RE: Juan Tabo Hills Estates Preliminary Plat, Project # 1005278

The purpose of this letter is to explain how the comments as contained in the DRB Official Notice of Decision (May 21, 2015) have been addressed. The following items have been revised and are being re-submitted for review and approval.

GRADING & DRAINAGE PLAN

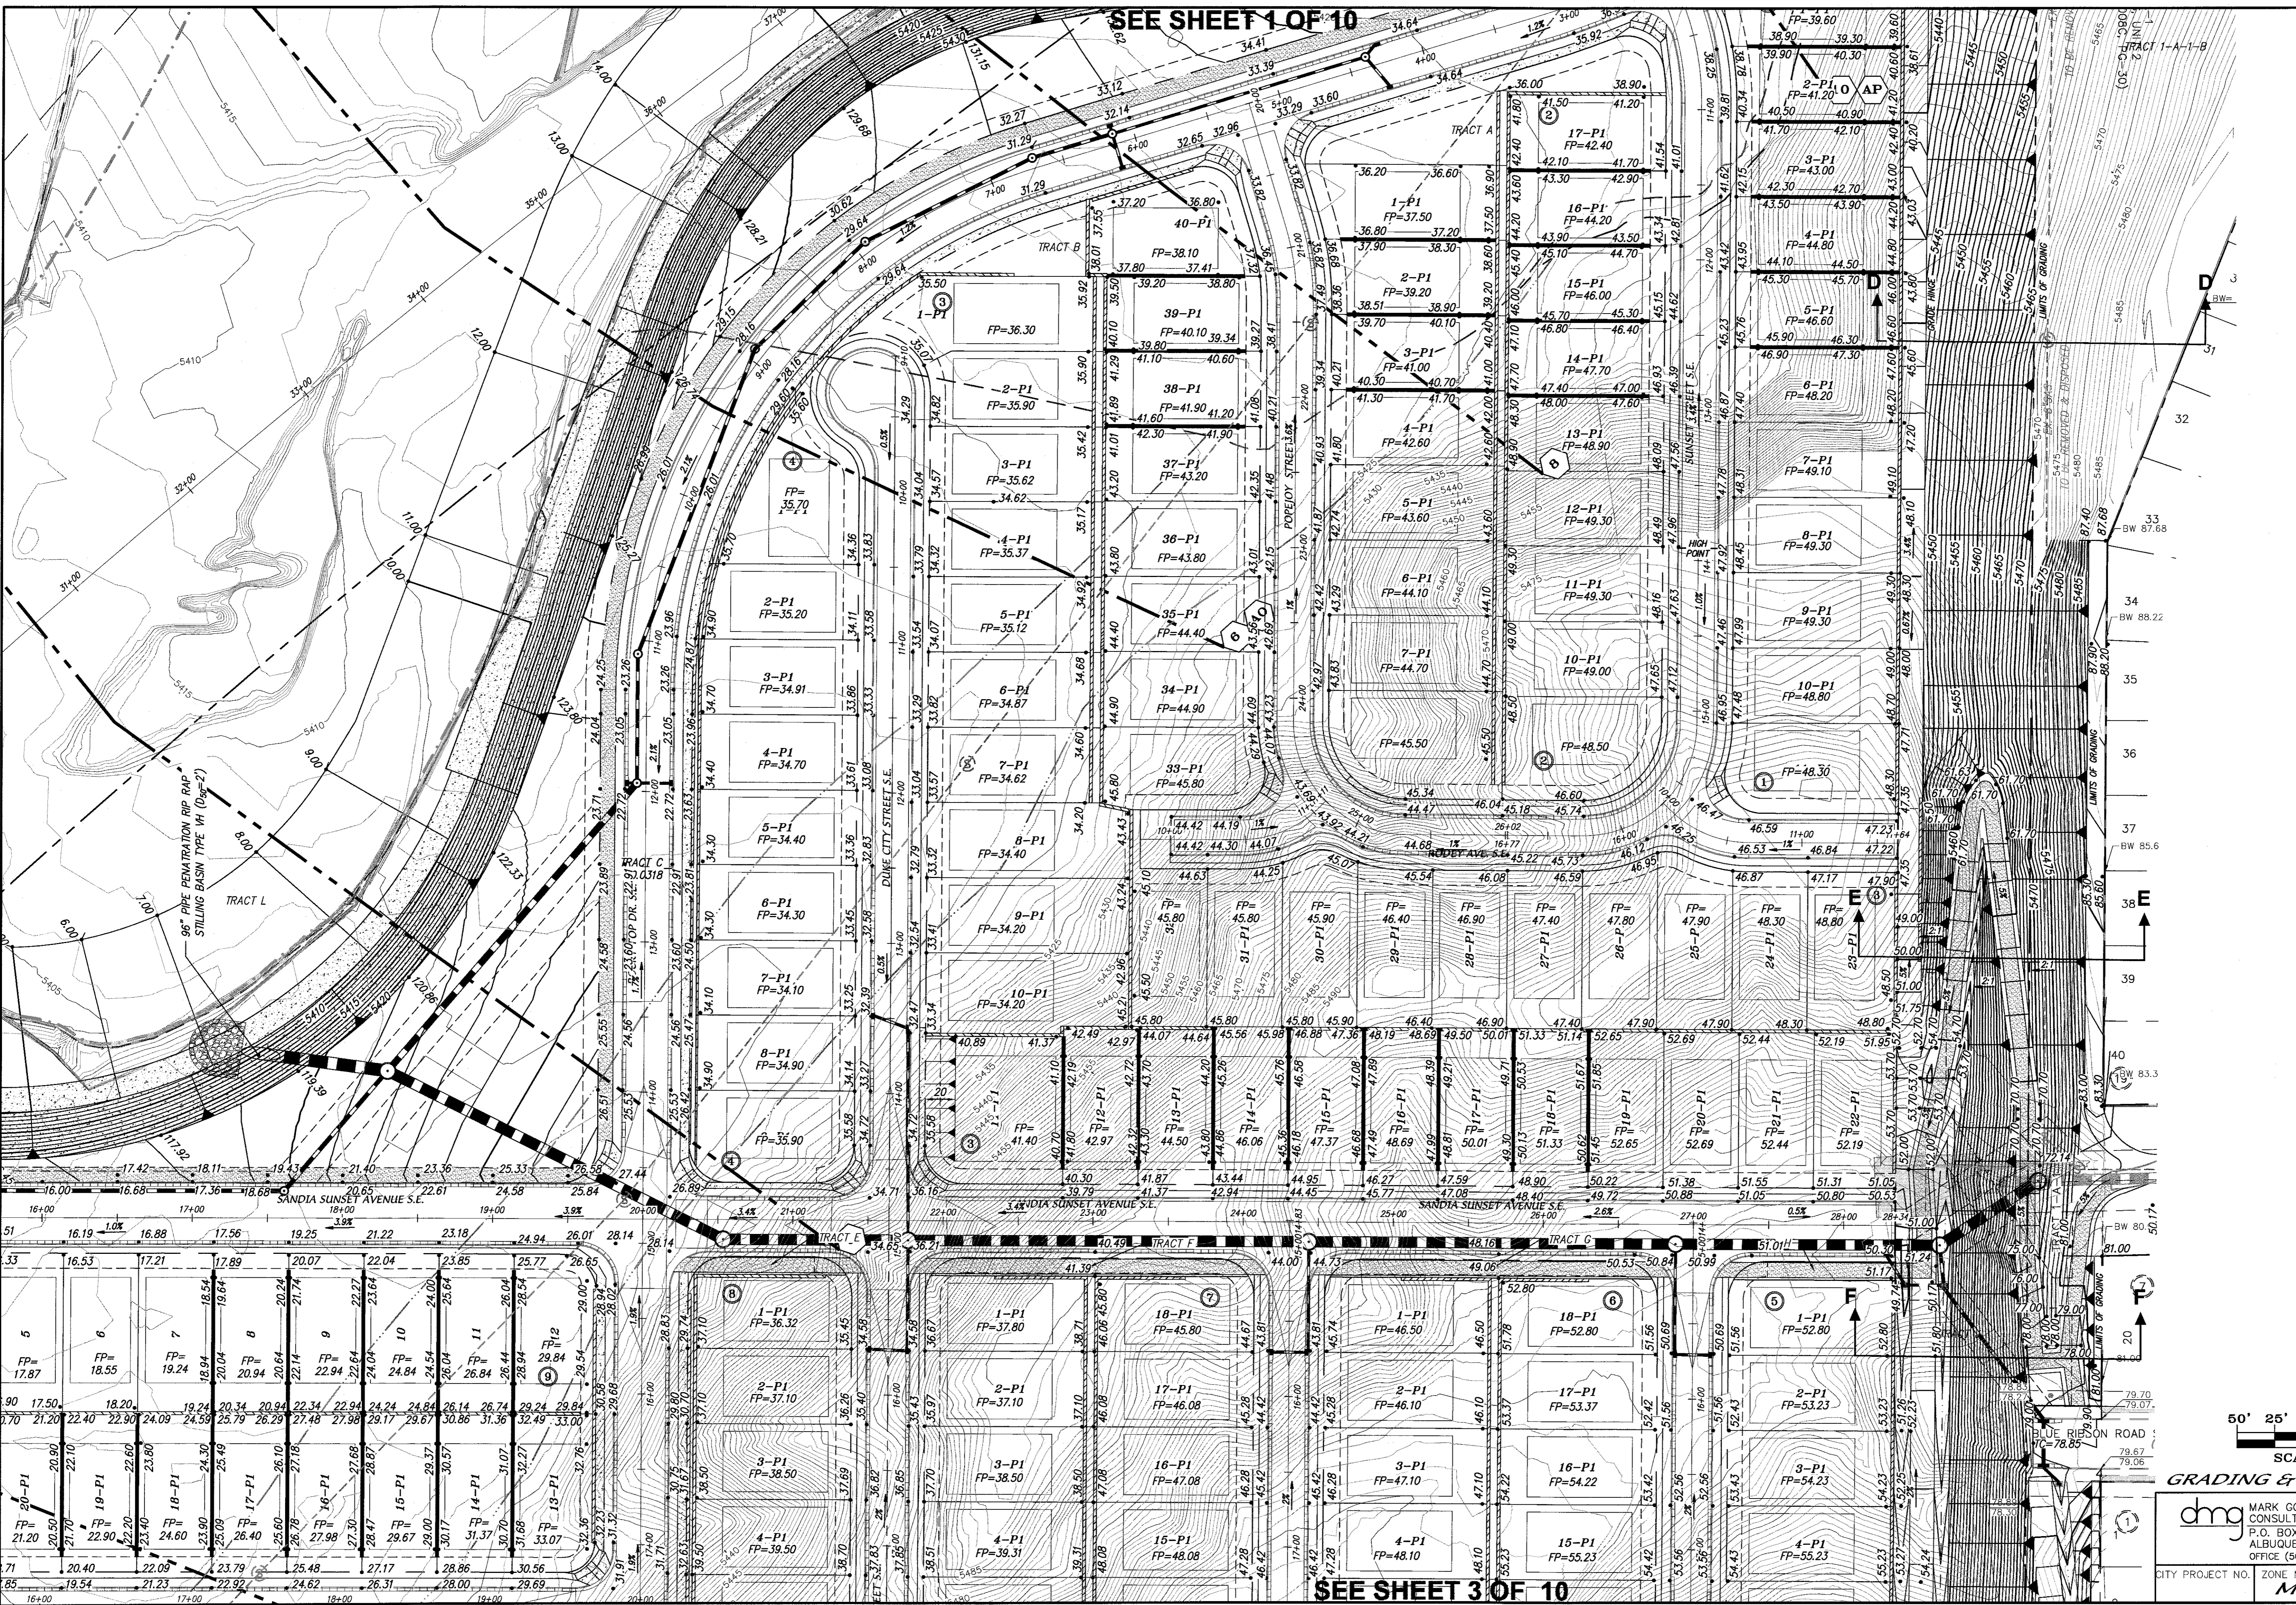
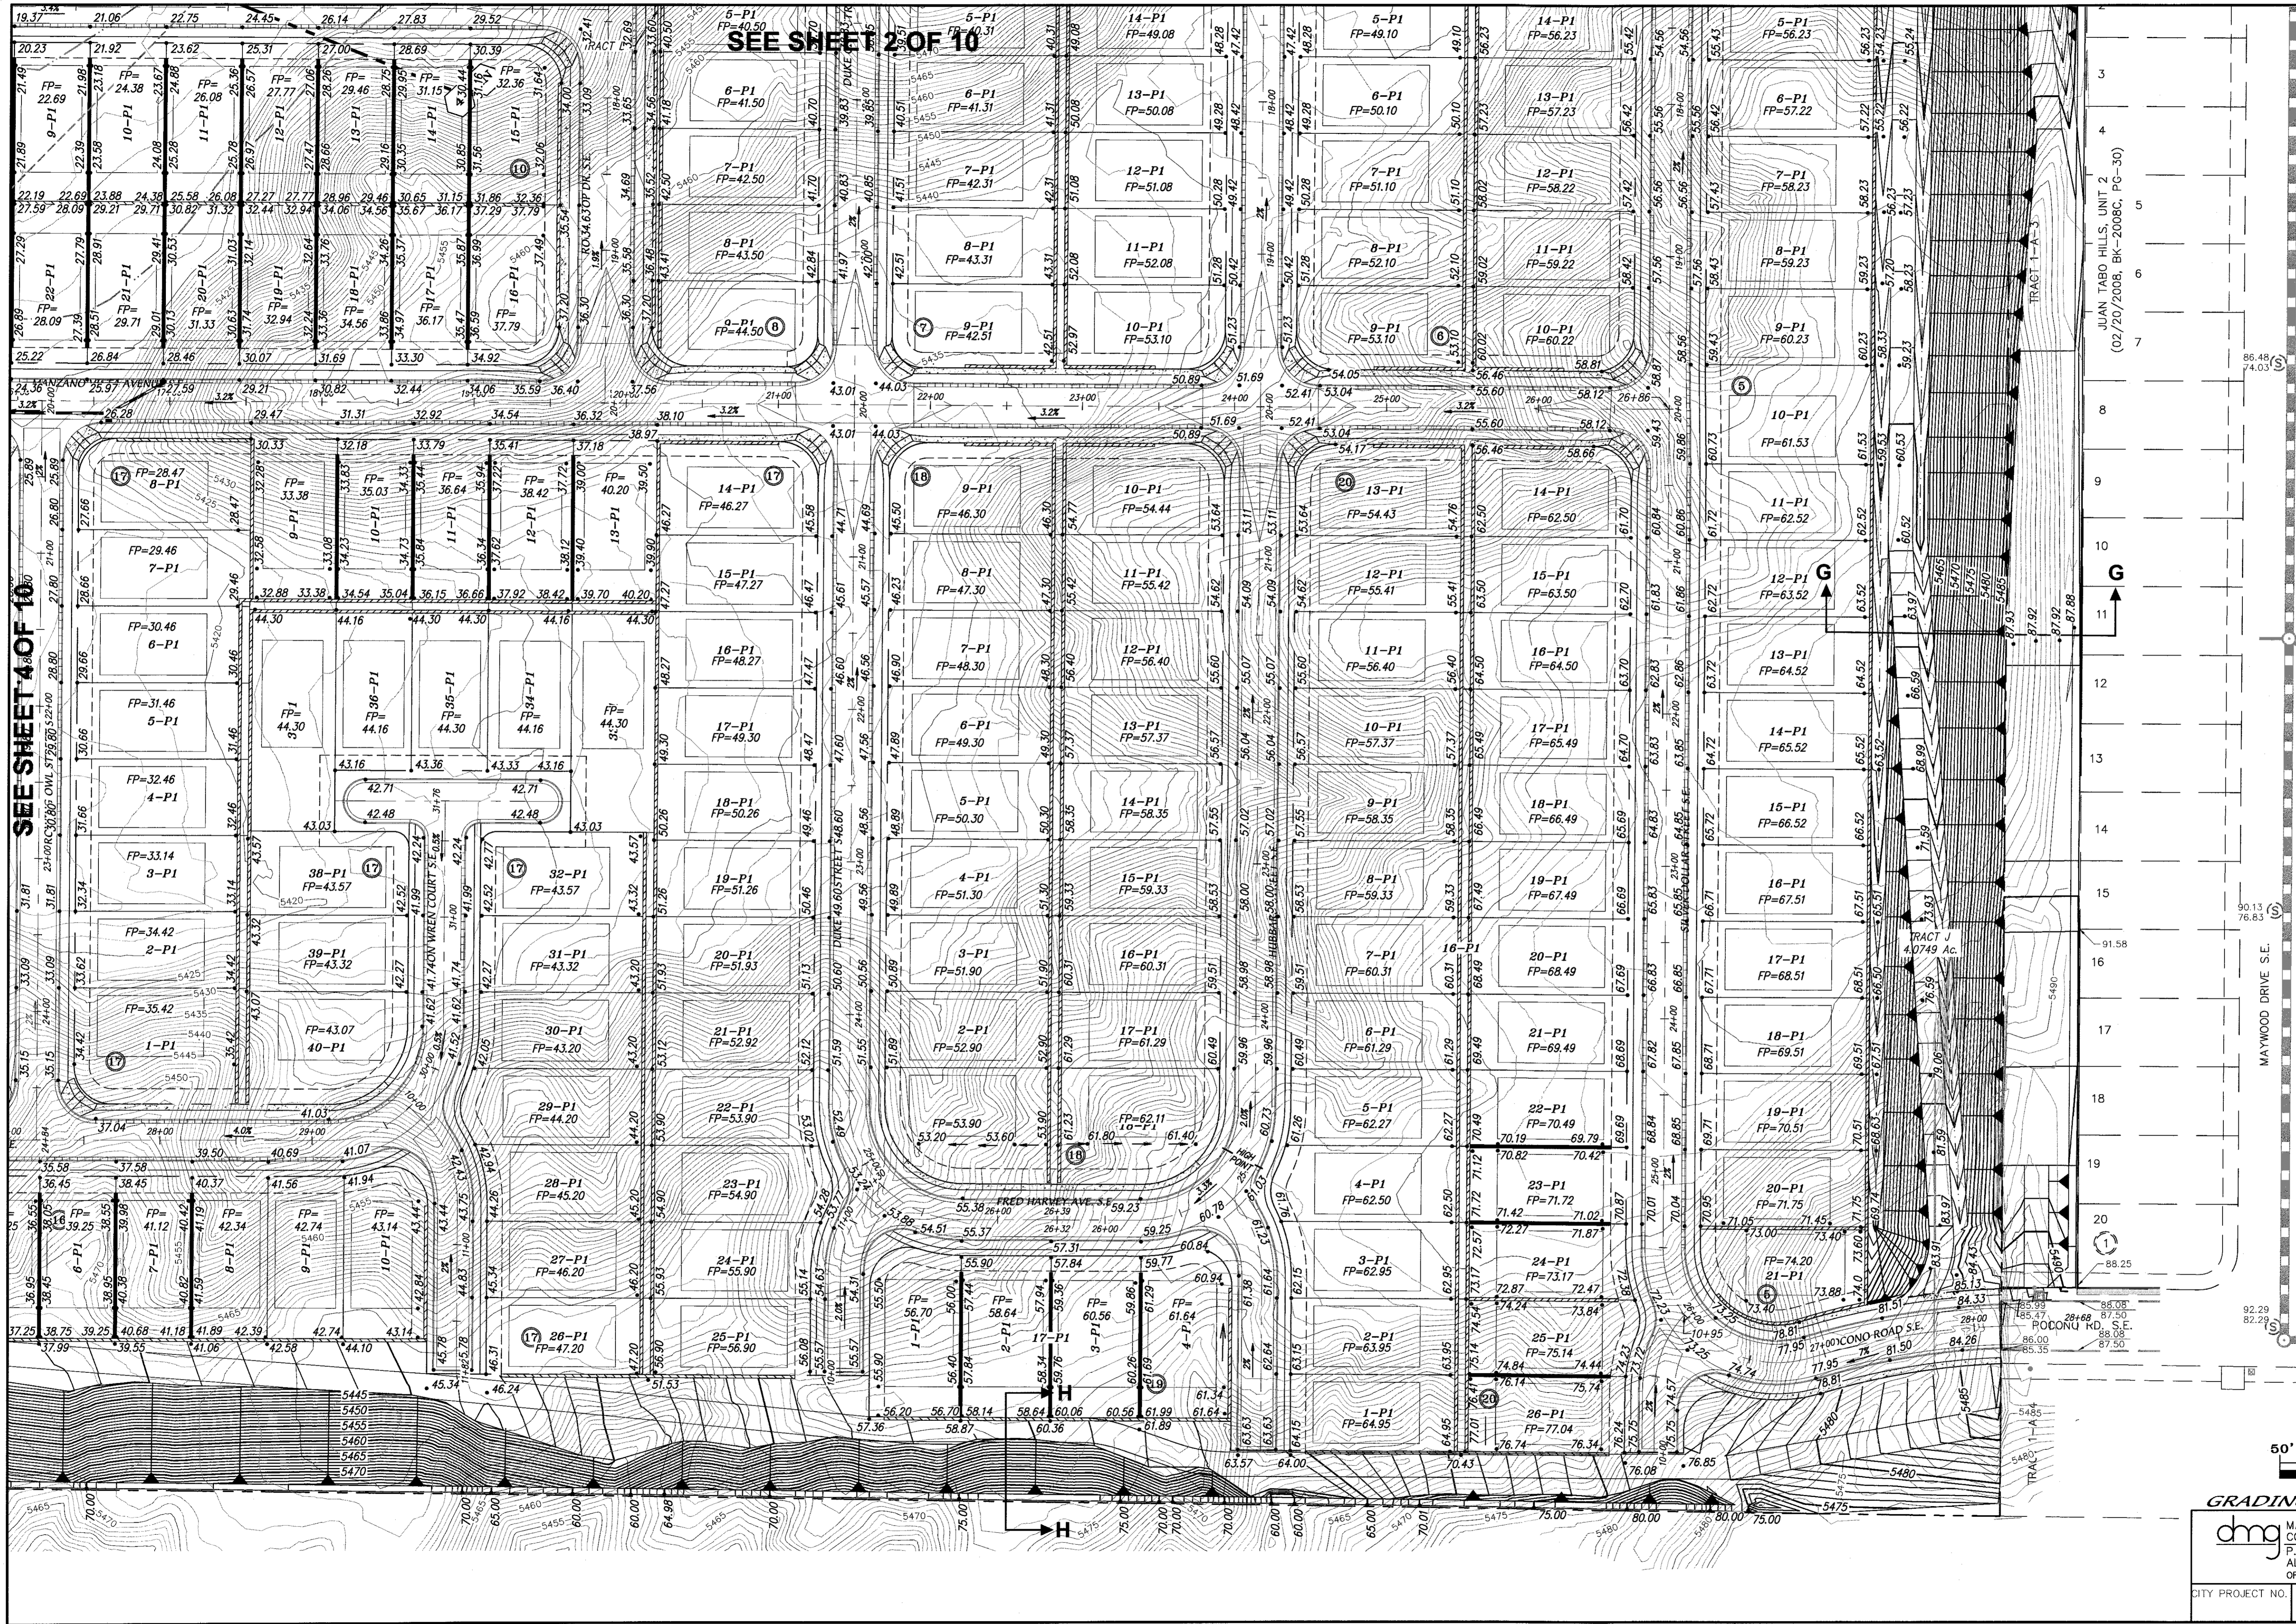
Parks and Recreation comments (1.) requesting changes to the landscape plan are now not applicable since the Landscape Plan and Tract A have been deleted from the site plan, though some separate exhibits have been provided to Carol Dumont to aid in her review. (2.) Previous agreement(s) say that the privately maintained Neighborhood Park is a private park which will be owned and maintained by the HOA. The private park is not subject to City review and approval and so has not been added to the infrastructure List (3.) The signature block on the infrastructure list has been changed to read Parks and Recreation Department. (4.) The Memorandum of Understanding between the USACE and the NMSHPO was distributed to DRB members during the first DRB meeting which outlines the approved plan of action for compliance with all cultural resource regulations (federal, state and local). (5.) The underground utilities are on the Infrastructure list and an updated copy of the Conceptual Utility Plan has been provided to aid in the review of the Infrastructure List. Contours and spot elevations have been

added to the Grading Plan. Separate permits will be obtained from the Corps of Engineers and AMAFCA that will address fencing along the arroyo. (6.) Ten foot wide AC Trails have been added to tracts H and J and are located in the best place available to insure privacy of the residents. AMAFCA has no objection to the approval of the Preliminary Plat and will be reviewing more detailed plans after Preliminary Plat Approval keeping in mind federal water quality standards and regulations.
